PLANNING CONSULTATION RESPONSE

Application No	2025/0717
Proposal	Erection of 1.8m boundary wall (retrospective)
Address	2 Shire Oak Drive, Elsecar, Barnsley, S74 8HU
Date of Consultation Reply	27 th October 2025
Consultee	Highways DC

Drawing Title
SHIRE-ELE-WH

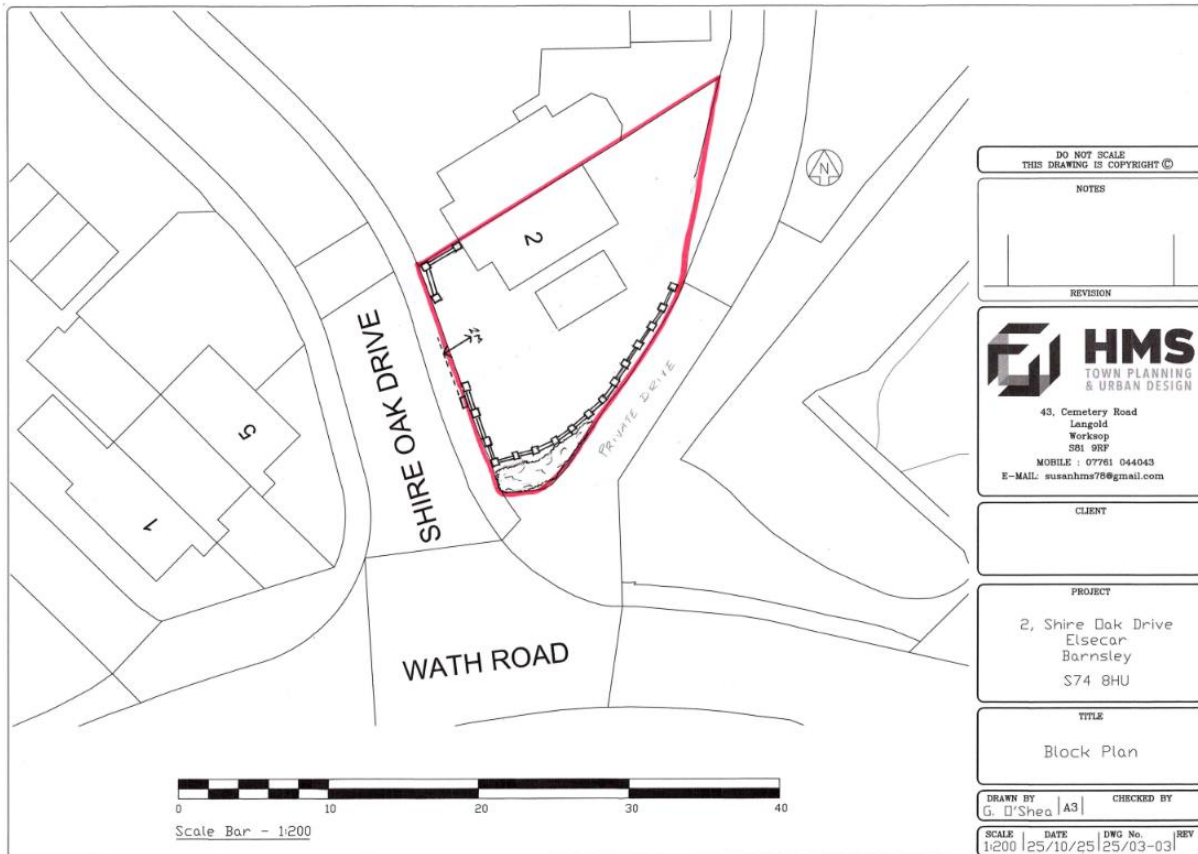
The new boundary wall has been built at a height of 1.8m, ordinarily it should therefore have a section not exceeding a height of 0.6m so that the 2m x 2m visibility splays are retained or have the corner chamfered so that the wall sits behind the visibility splays as per the access to the block of garages on the opposite side of the road.

Notwithstanding the above, in recent years a metal utilities cabinet has been installed within the footway to the front of the property, this has had the effect of moving pedestrians away from the boundary wall as they approach the driveway and may possibly allow the 2m x 2m visibility to be achieved.

In view of this unusual circumstance, the applicant may wish to submit an accurate site layout plan which includes the footway and metal cabinet so as to determine whether the pedestrian visibility is achievable or not. The 2m 'x' distance of the pedestrian visibility splay should be measured back from a line that is level with the front of the metal cabinet.

I note that the red line boundary on the submitted location plan does not include the full site curtilage and the Block Plan does not accurately depict the shape of the site or the position of the walls as they have been erected.
